From: Paul Cann
Sent: 25 August 2017 13:52
To: Planning.Responses
Subject: RE: Planning Consultation on LU/211/17/DOC

Condition no.12

APPLICATION LU/211/17/DOC
NO:

Registered: 23-JUN-17
Site Address: 6 & 7 Courtwick Park Cottages Courtwick Lane Littlehampton
BN17 7PD

Test Hole No: BHI
Test No: Test No 1

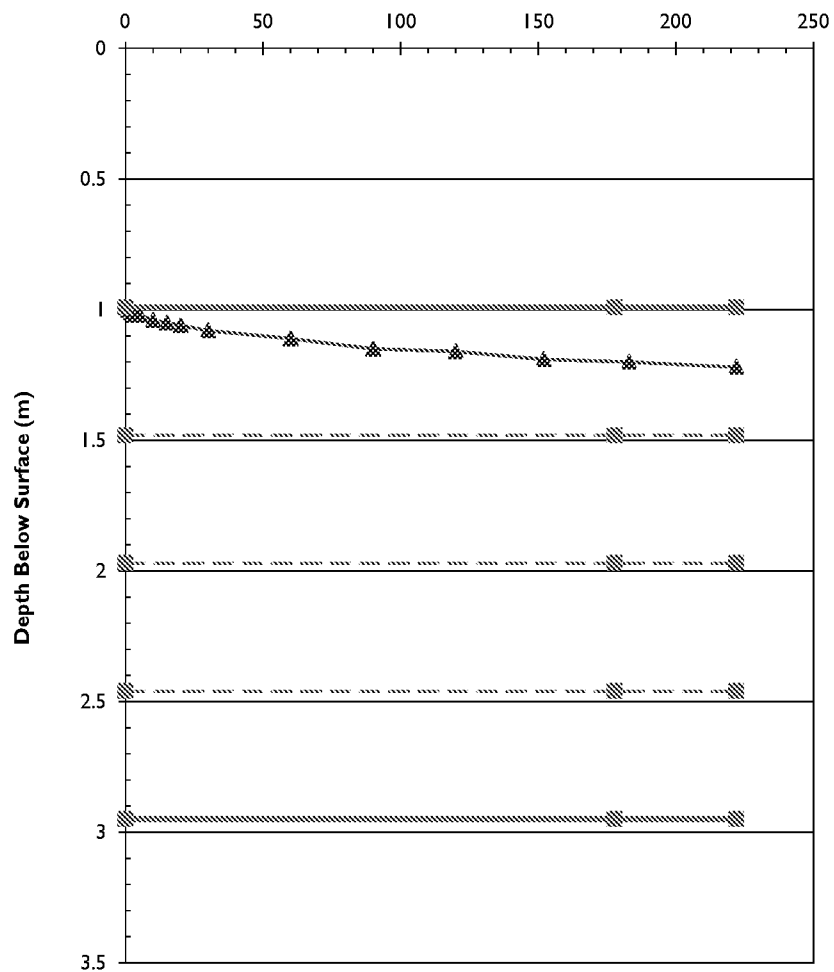
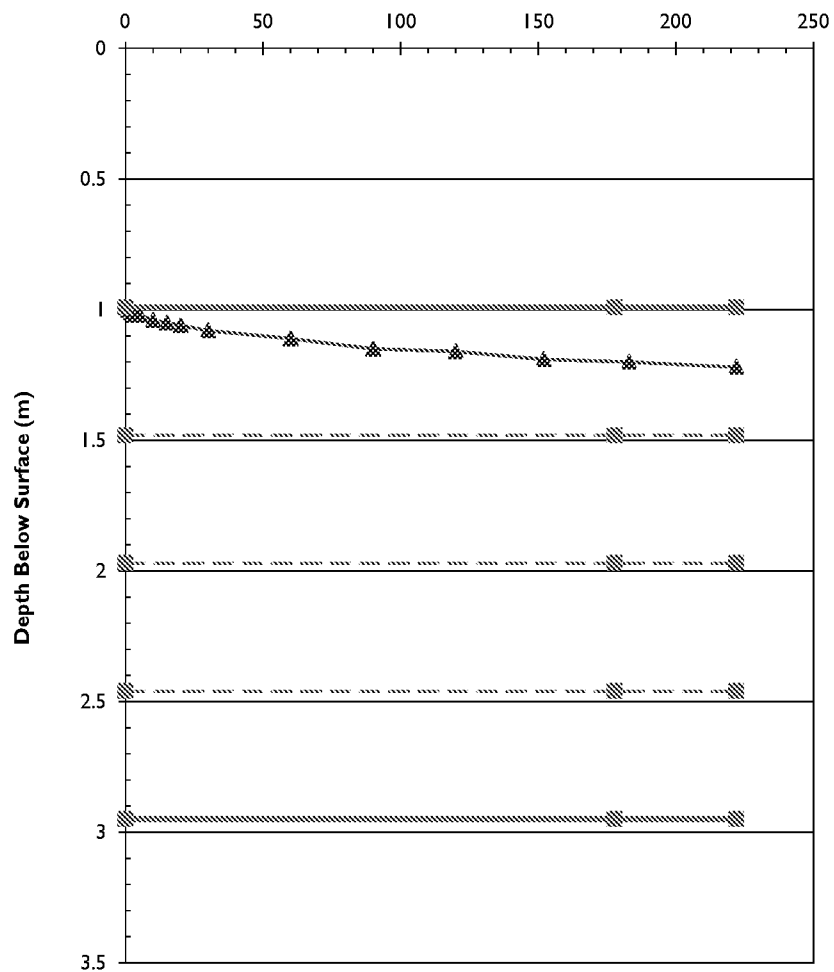
1. In an email dated the 2nd August 2017, the applicant has stated that soakaways are no longer deemed viable due to poor percolation rates. Please supply full details of the percolation tests and the calculated rates.
